# CITY OF ALBUQUERQUE

**RE: Goodwill**  
**270 98<sup>th</sup> Street NW**  
**Conceptual Grading & Drainage Plan**  
**Engineer's Stamp Date: 8/9/2024**  
**Hydrology File: K09D048E**

Site Overflow Check (Curbed Concrete Channel)

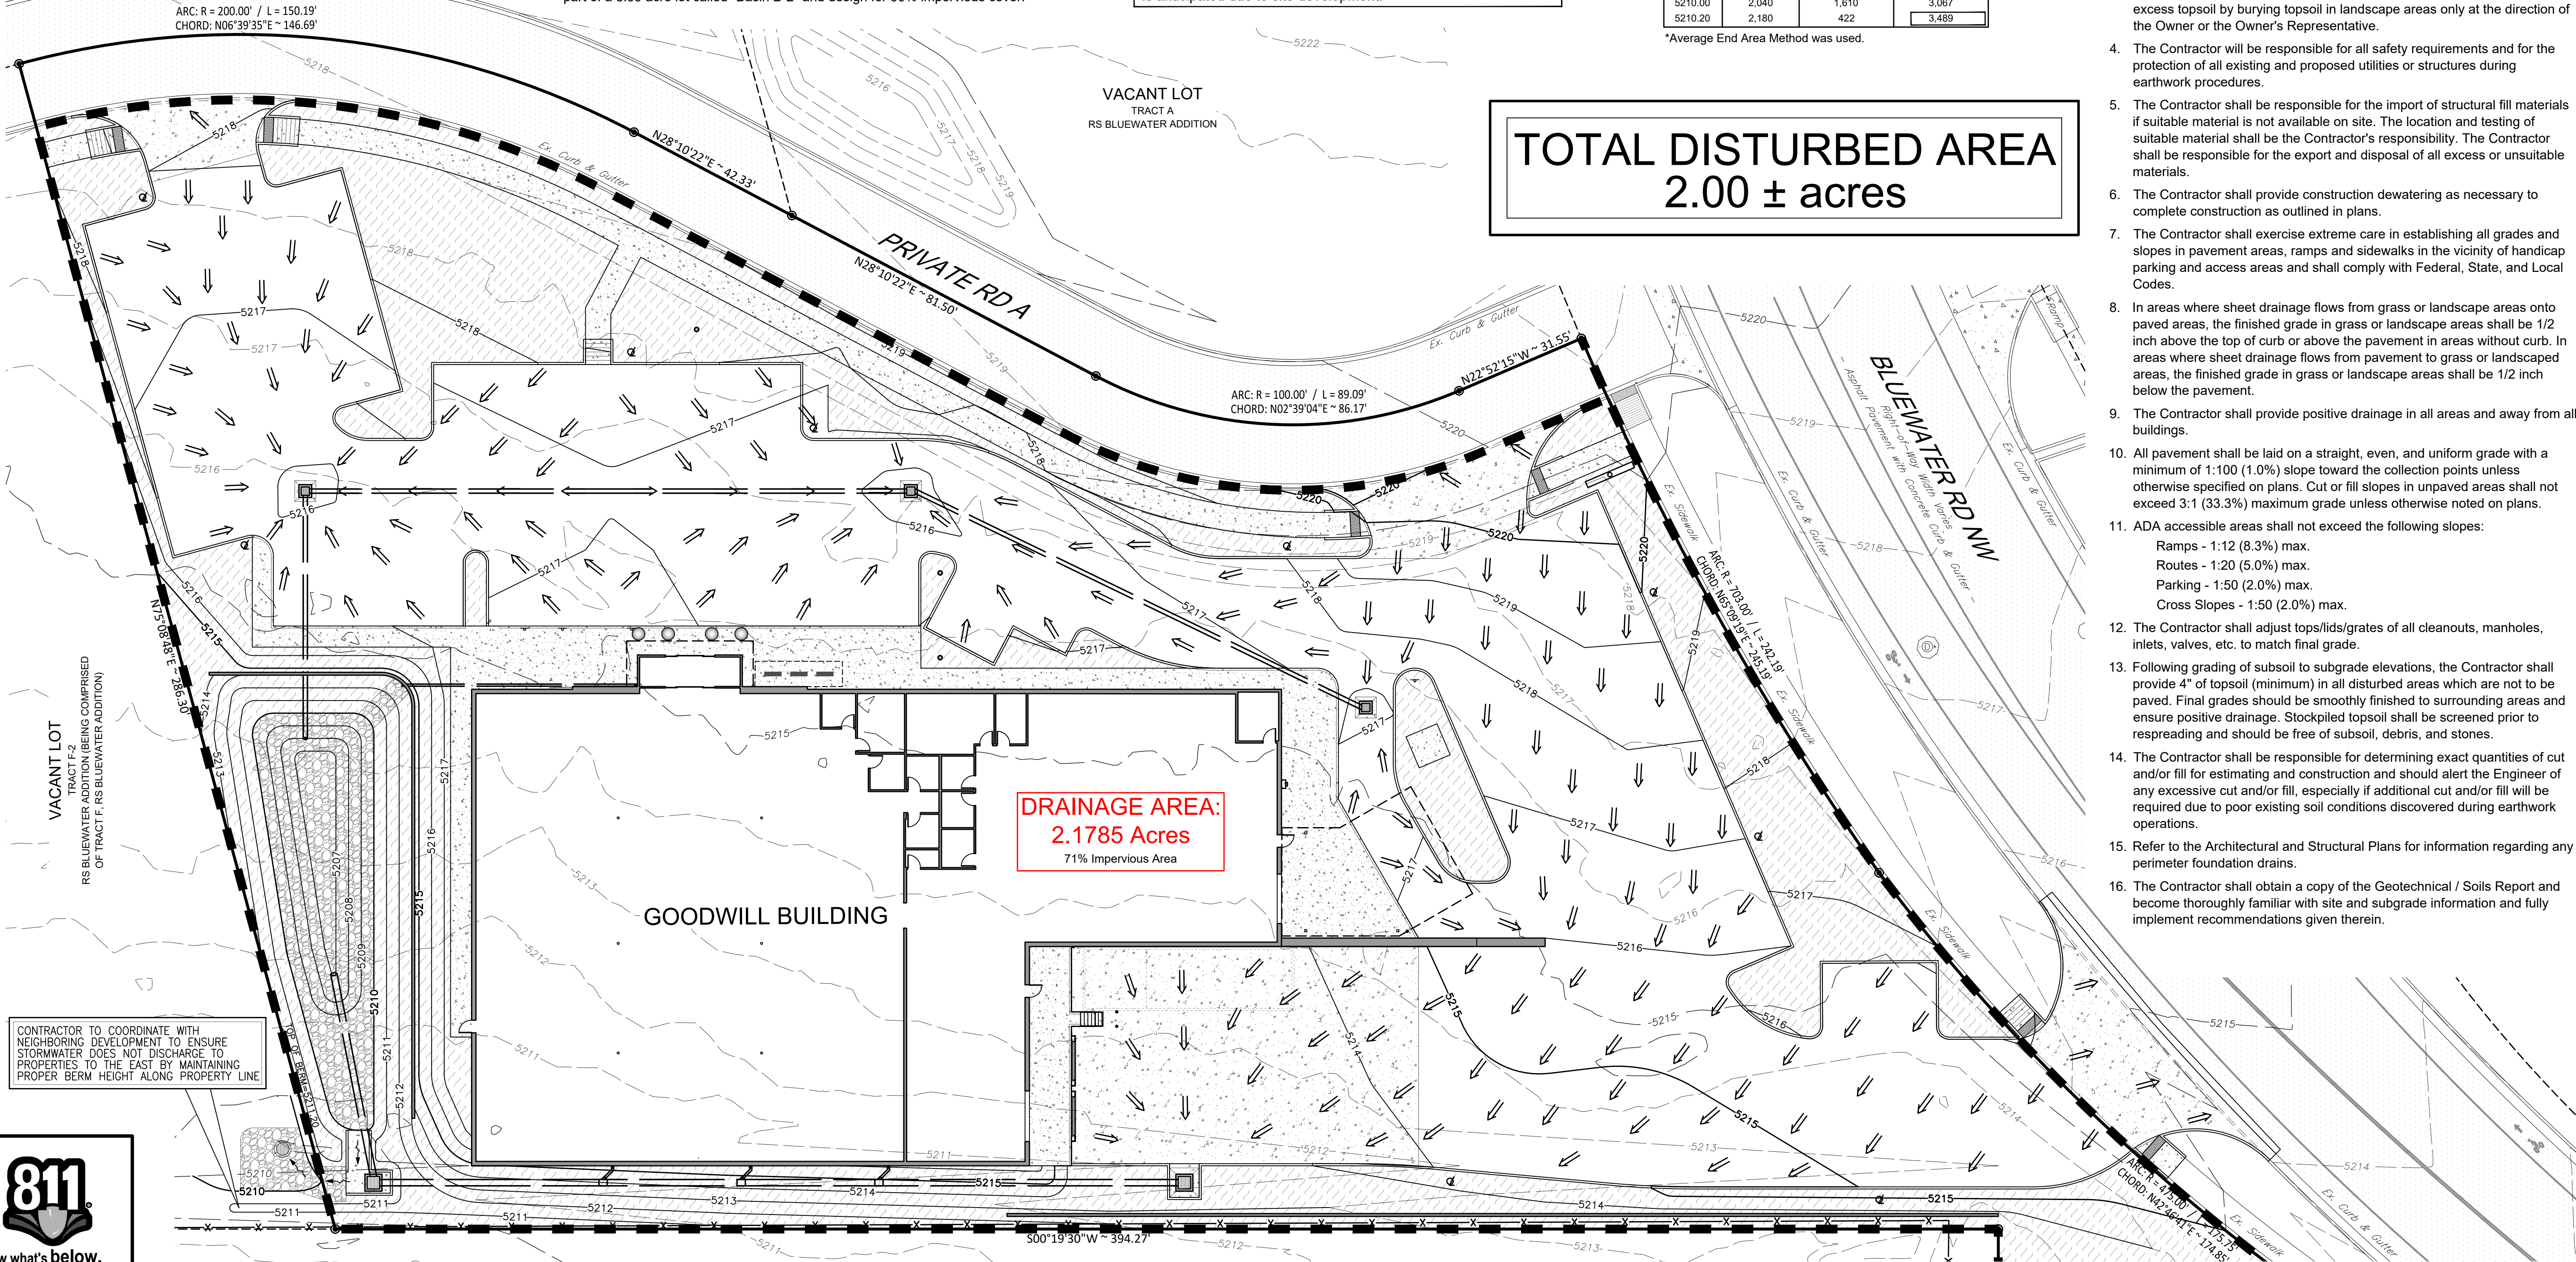
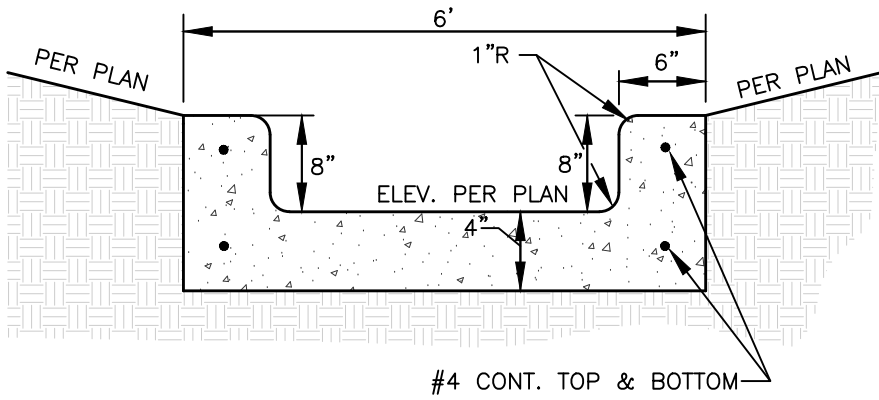
1. Please show the connection to the (future) 18" storm drain at the SW corner of the site that is being built by the Caliber Collision project (#K09D048D) and update the Overflow description.

In an emergency the infiltration basin would overflow through a 5' wide 8" curbed channel & grate inlet and will discharge along the existing established drainage ditch along the back of the neighboring property as designed per the Drainage Management Plan. Proposed Q-100 = 8.13 cfs
